**Formal objection - planning reference 2023/93082**

**Discharge conditions relating to planning permission 2022/91730**

**Location: Land adj 60 Northgate, Ceckheaton, BD19 3NB**

**Development: Demolition of former dairy/snooker centre/storage and erection of 9 light industrial units**

Scott Lane, Cleckheaton, BD19 4JY – S116 Sewer Closure V326571

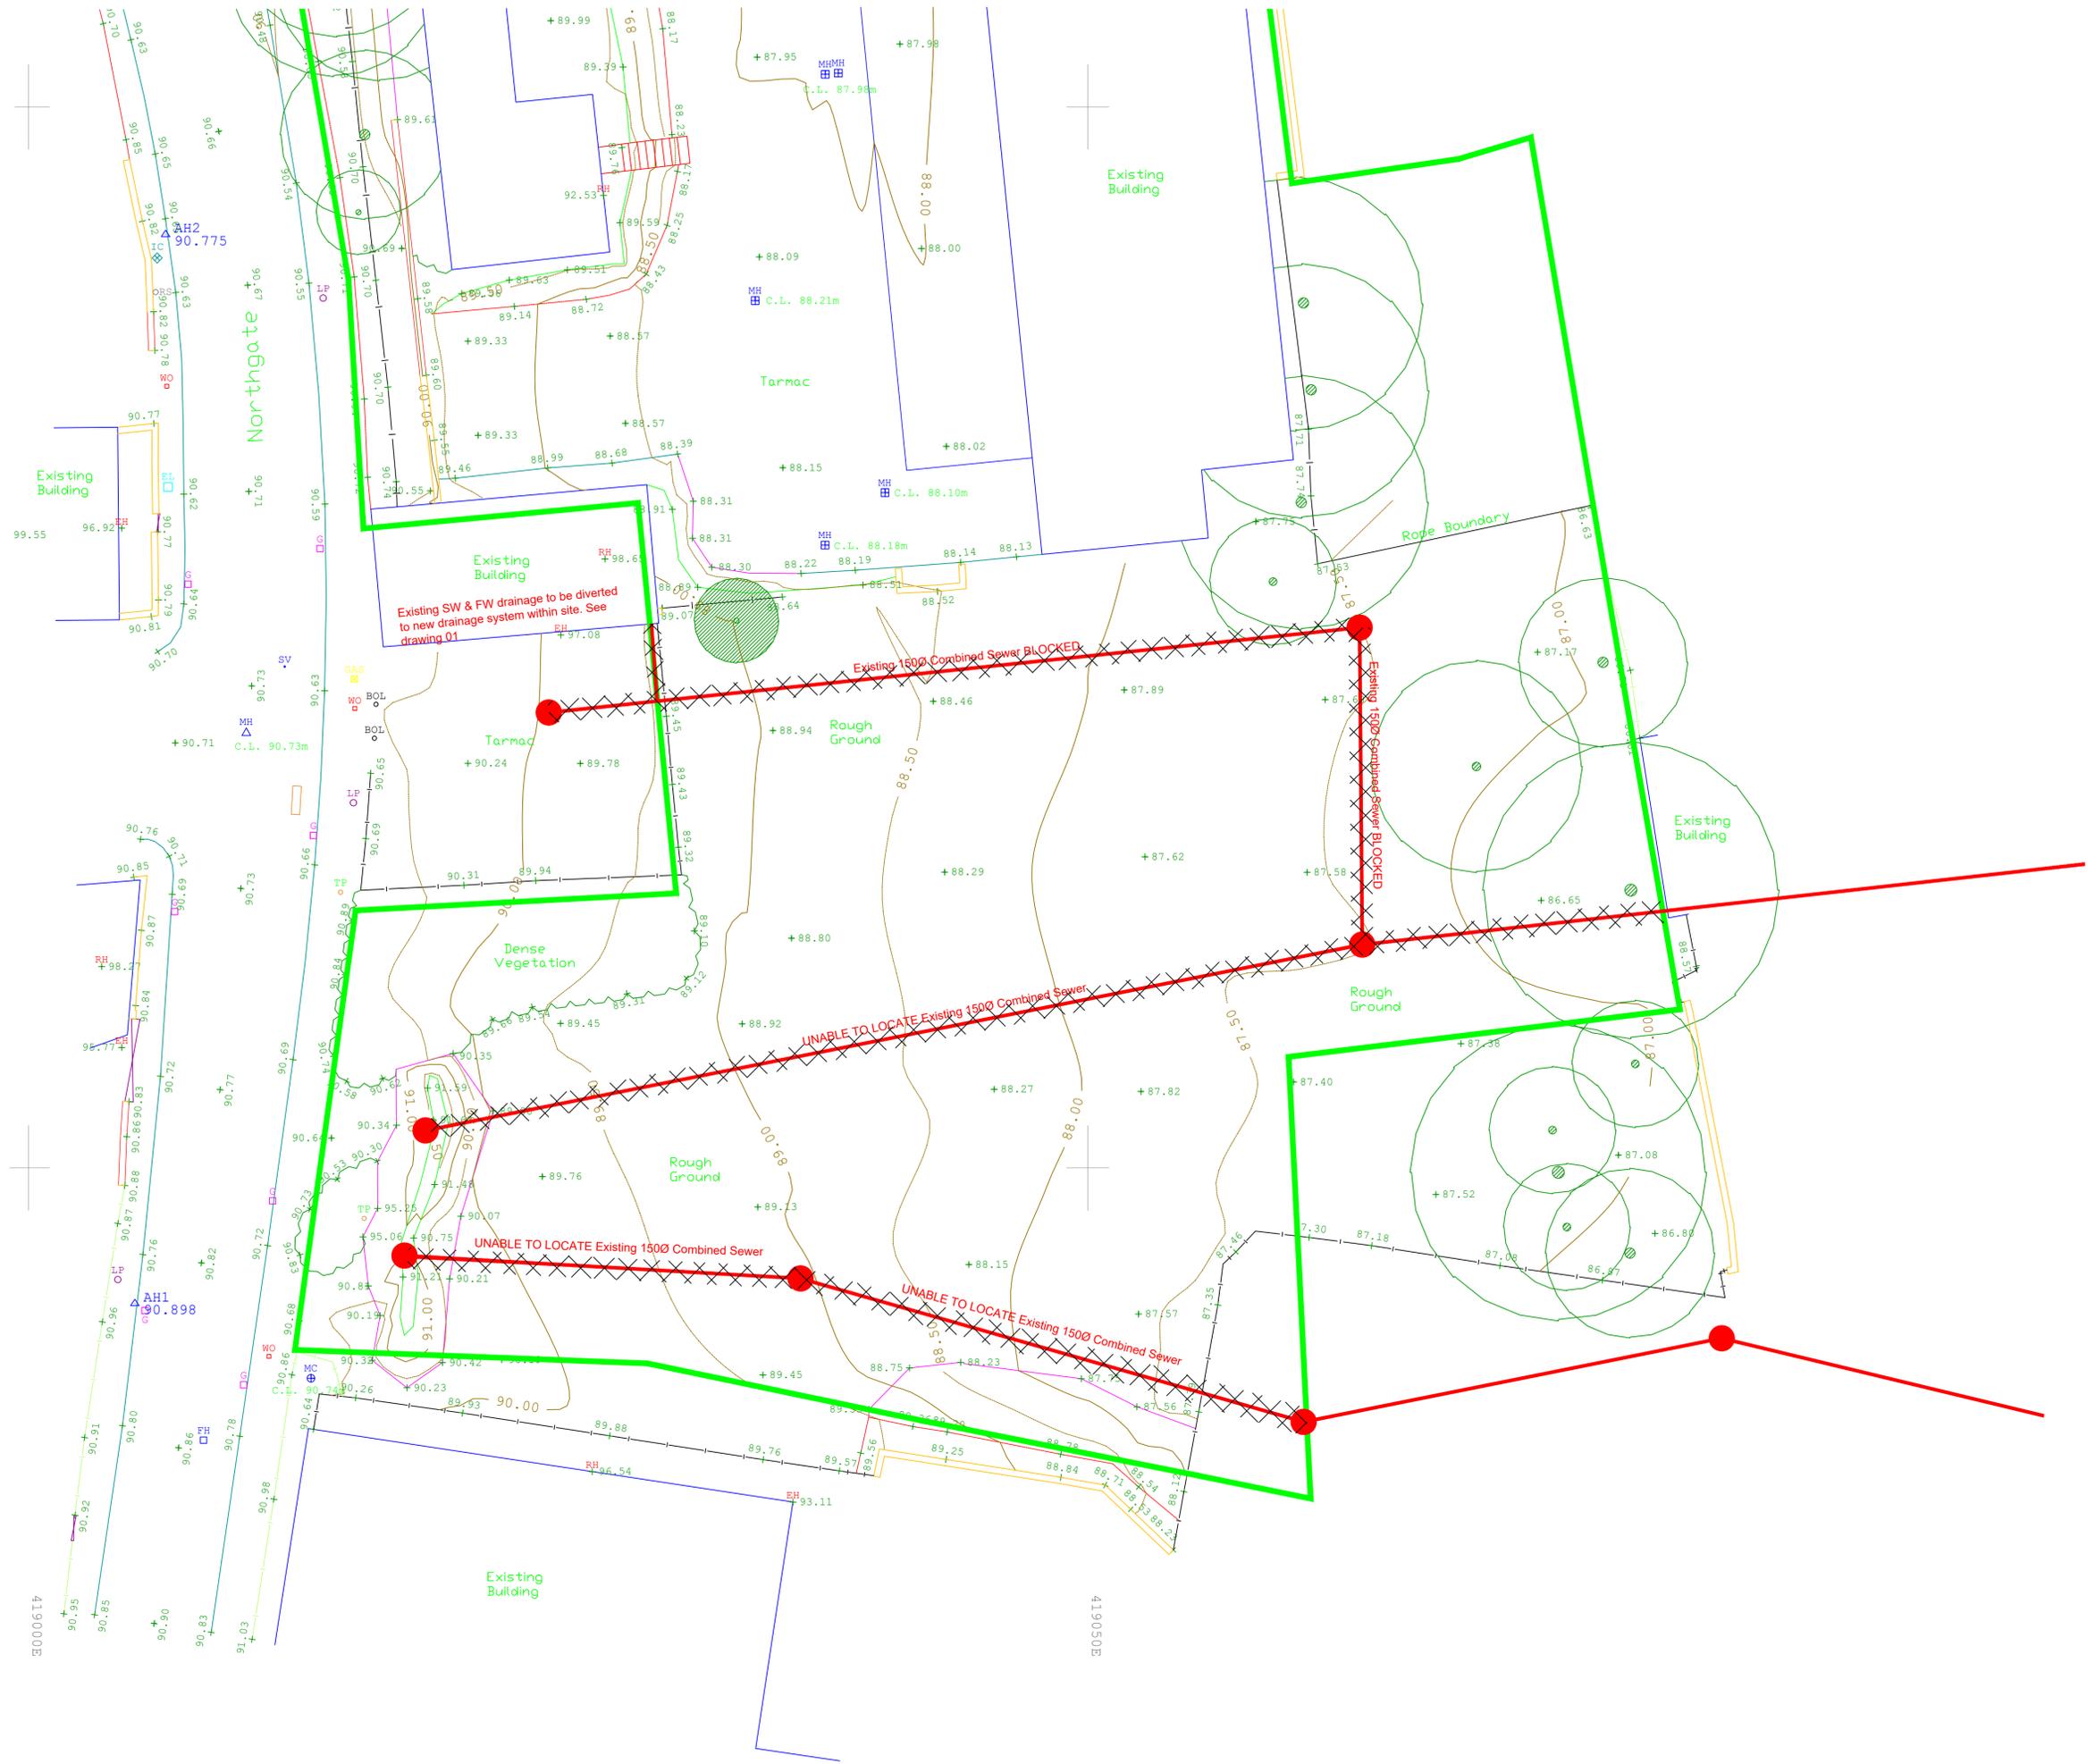
The approval given relates to drawing number EWE/2514/03 (planning document General 1012324).

As Yorkshire Water fails to note, that drawing misrepresents the boundary of the development site in relation to my property for the purpose of obtaining approval.

The boundary of the development site - represented in green on drawing EWE/2514/03 - has been inaccurately drawn by EWE Associates so as to be within the boundary of my property.

It's clearly apparent from the drawing that the sewer to be abandoned is not wholly within the development site - that it serves my property, running from my building (edged in blue) across my tarmac car park to the adjacent rough ground. Closure of the length of sewer concerned would therefore have immediate unacceptable consequences for my property.
